RECYCLING & REFUSE TRANSFER STATION

BARBARICK WASTE TRANSFER STATION

SITE PLAN EXHIBIT - AL2310

SITE PLAN EXHIBIT - AL2310

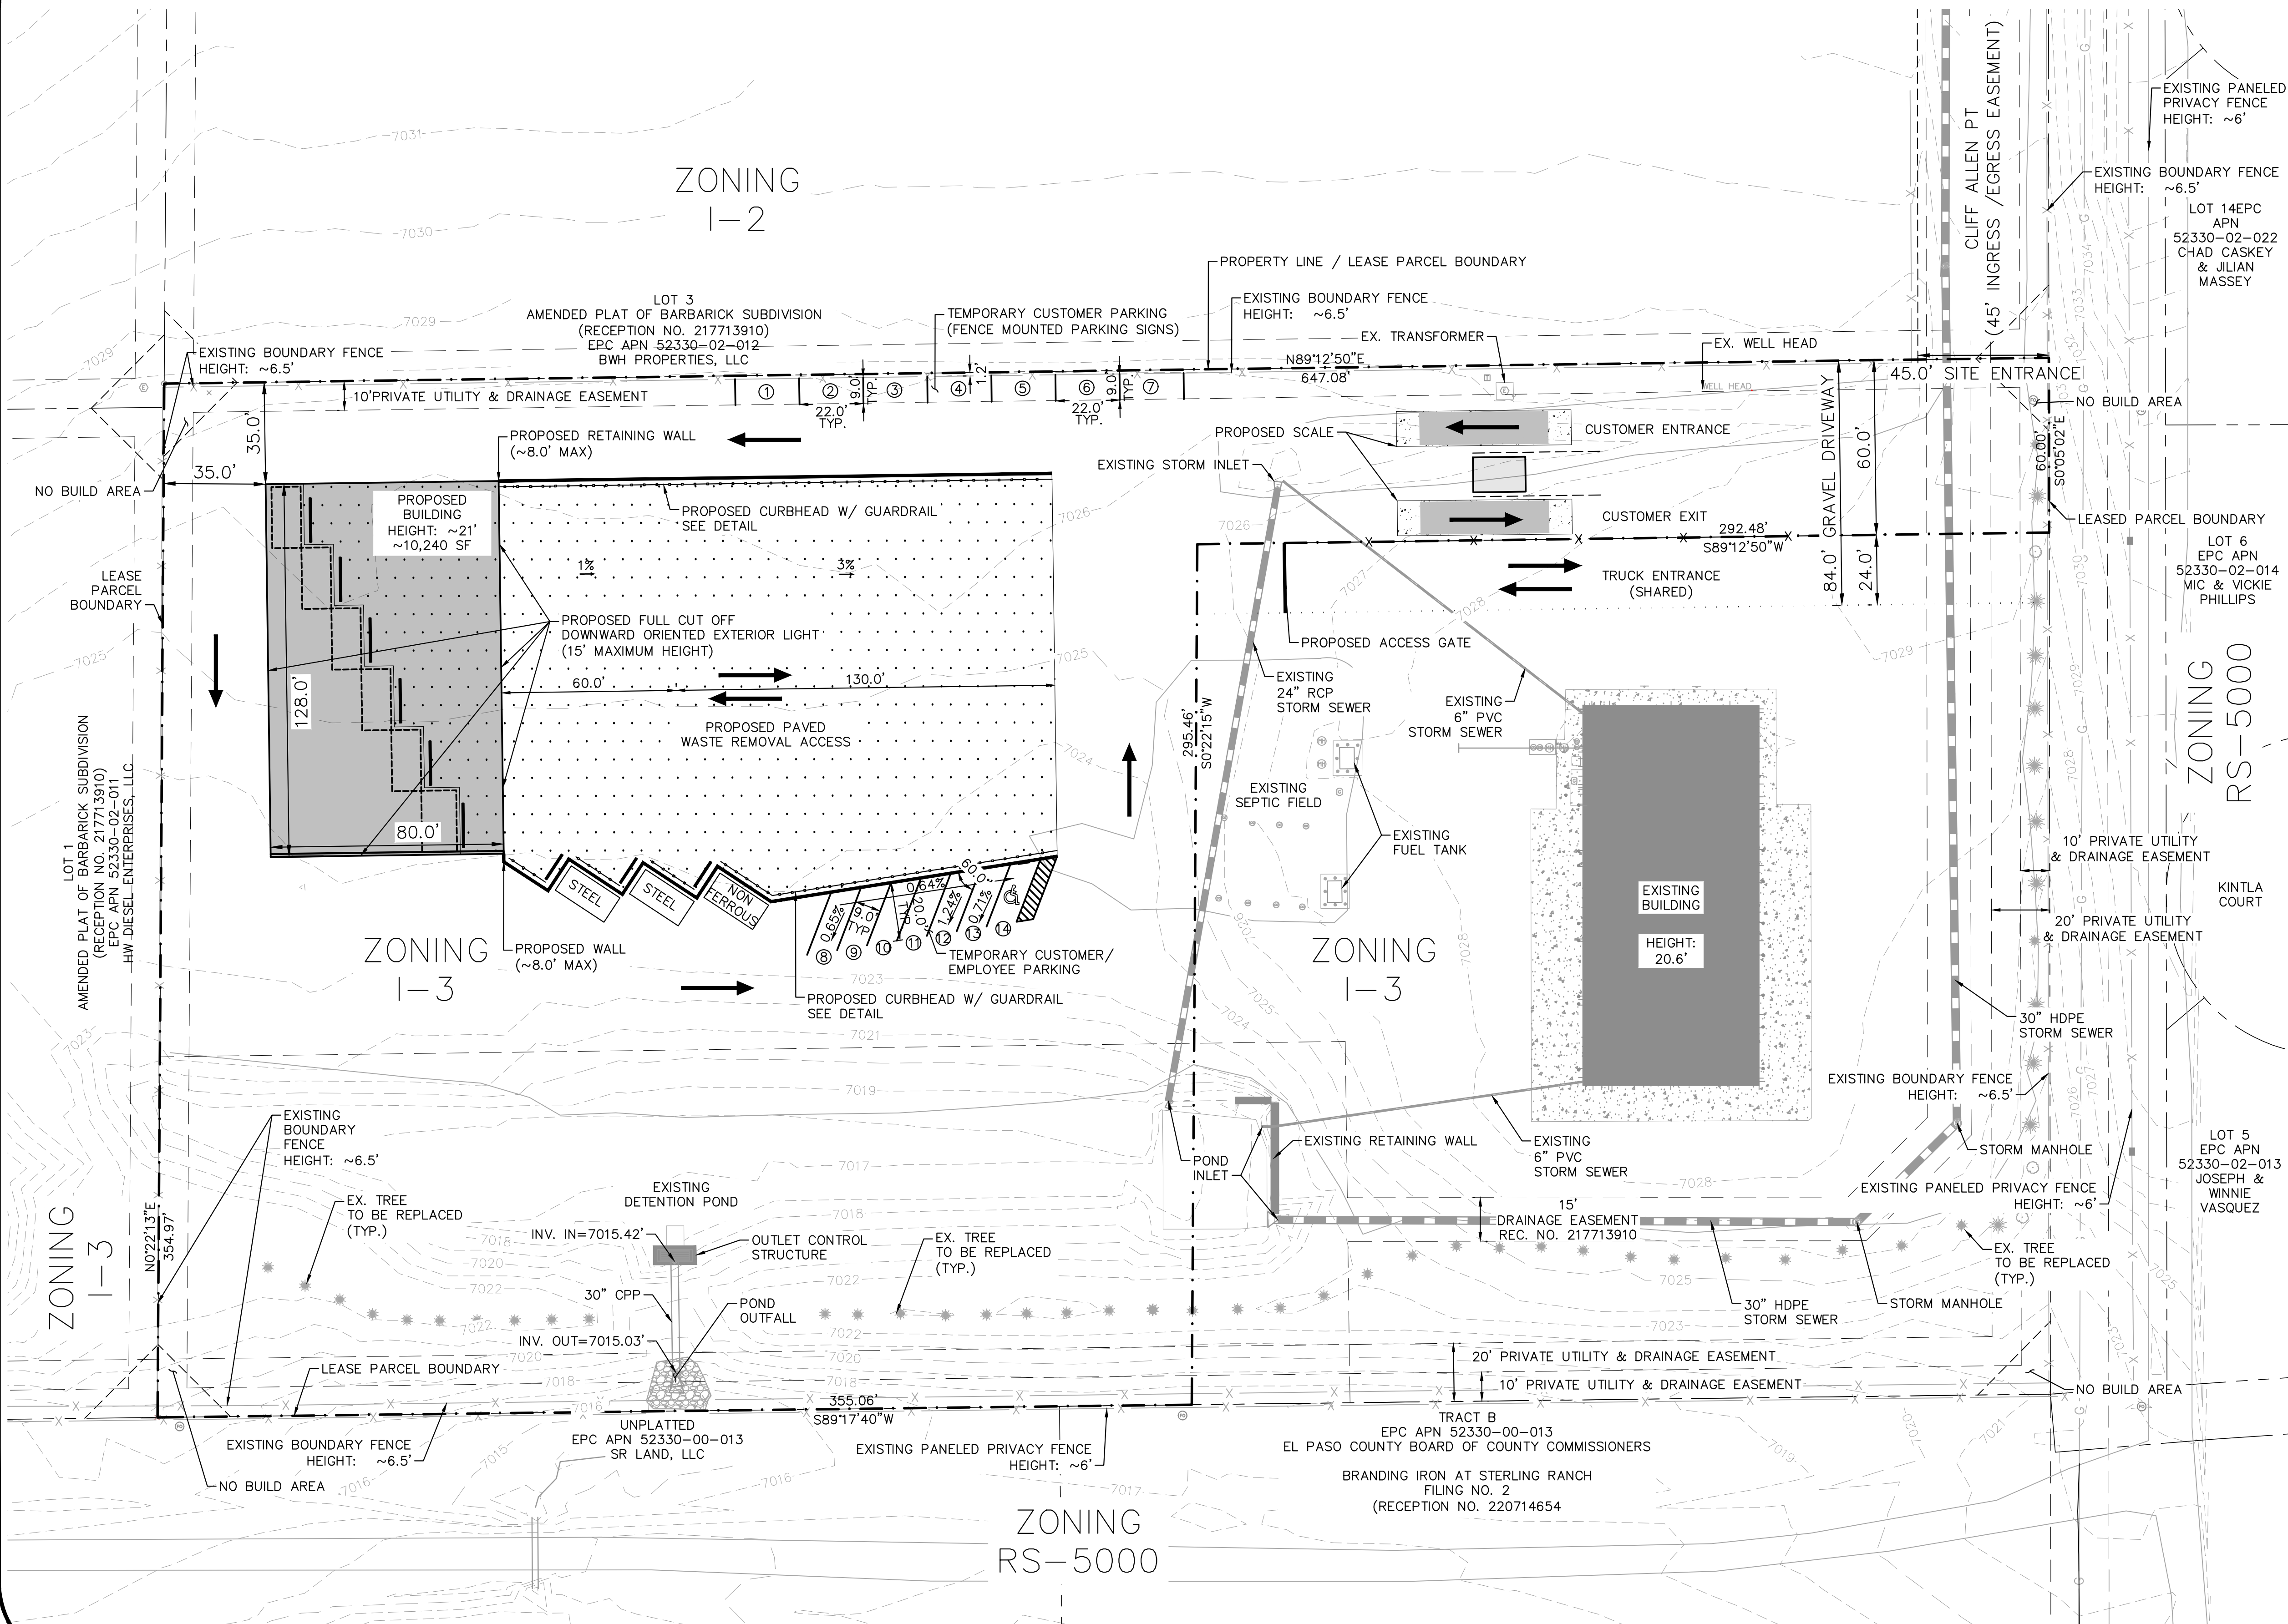
UNRESOLVED V1 COMMENTS:
 v2:
 -signage? provide dimensions
 -required vs provided parking (6-2 minimum parking requirements table)
 industrial use requires 1 space/750 sq ft of use
 -ADA parking,ramps,signs
 - location and height of outdoor illumination
 - well placement

The following note should be added to all site development plans or non-residential site plans, as applicable, prior to PCD approval: The parties responsible for this plan have familiarized themselves with all current accessibility criteria and specifications and the proposed plan reflects all site elements required by the applicable ADA design standards and guidelines as published by the United States Department of Justice. Approval of this plan by El Paso County does not assure compliance with the ADA or any regulations or guidelines enacted or promulgated under or with respect to such laws.

KH RESPONSE:
 - No signage is proposed on site at this time
 - required vs provide parking has been included. Req'd: 13.65 ~14 spaces. Provided: 14 spaces (1 ada space) It is worth noting that customers will not park on site, but drive to the drop off location, relieve themselves of their recyclable materials, and lastly pay and leave.
 - Approximate outdoor lighting locations and height provided. No lightpoles are proposed, all lighting is to be building attached, downward oriented full cutoff lighting fixtures @ maximum 15' height.
 - Existing well location has been updated to show in the plan.

KH RESPONSE:
 - Updated to include the following note.
